Online Comment

Application H16-0423-18
Location 11 Tower Lane Spalding PE11 2RG
Proposal Replacement dwelling following permission for demolition of existing dwelling

Name Ian Marshman, Historic Environment Officer
Address Lincolnshire County Council Places Team Lancaster House 36 Orchard Street LN1 1XX

Date Submitted 14-11-18
For/Against Comments

Site Block Plan
1 : 250

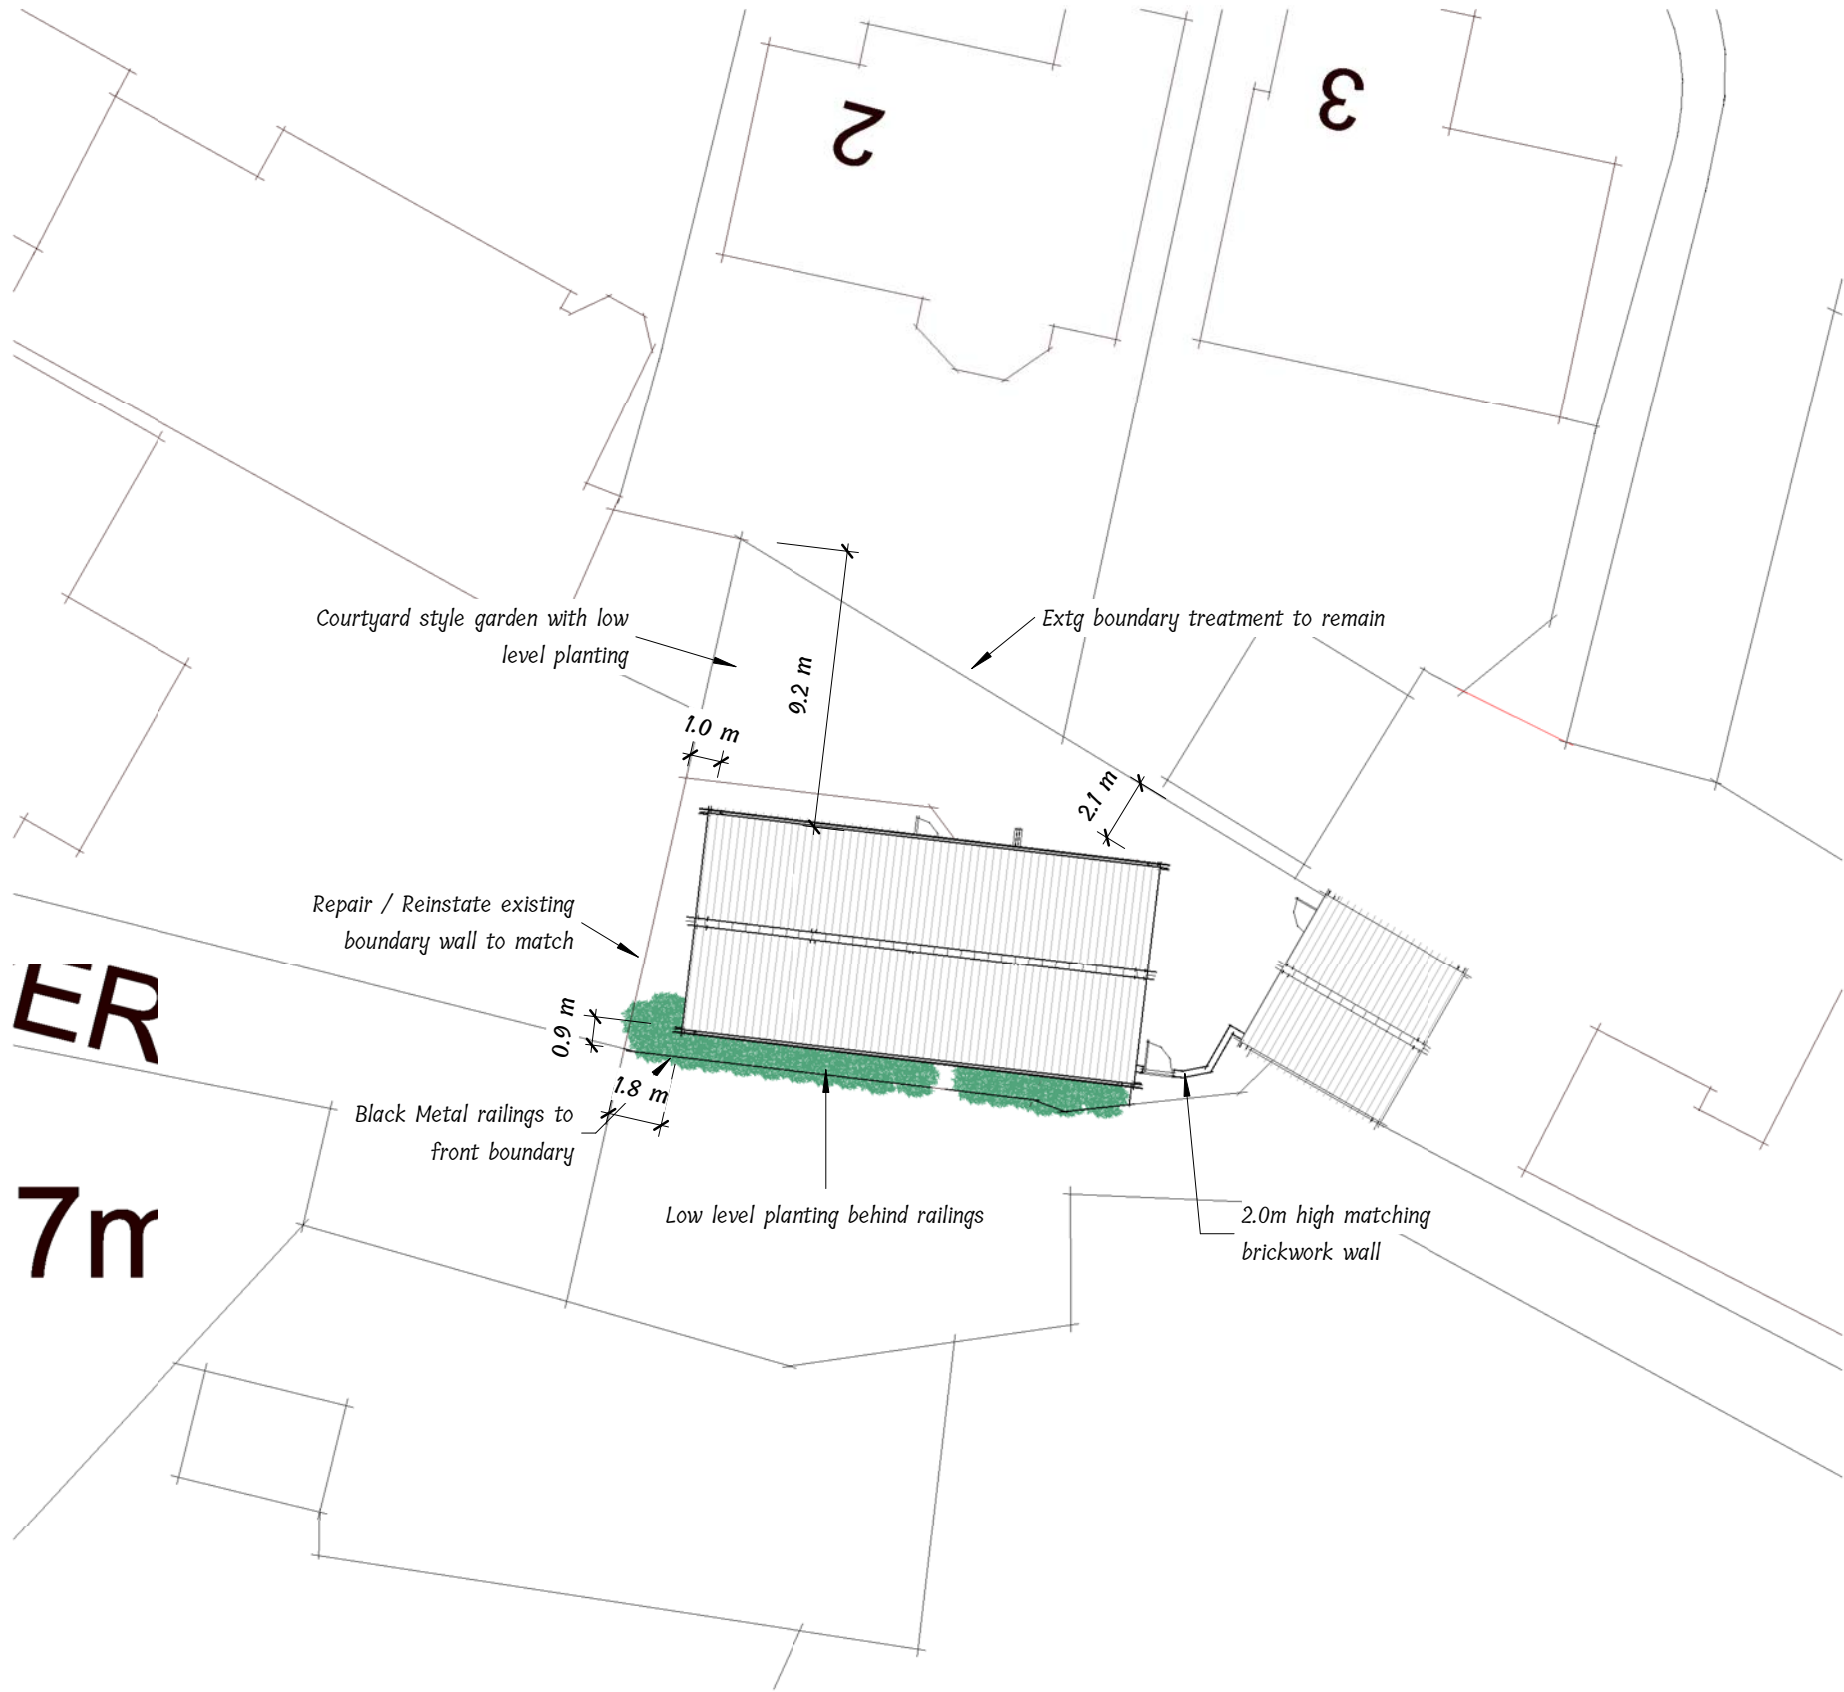
However, we would like to reiterate our earlier comments regarding the need to ensure that the Listed wall at Tower House is not damaged during the demolition of the remains of No. 11 Tower Lane. Our original recommendation to require the developer to commission a scheme of works for the archaeological monitoring of all groundworks also remains unchanged.
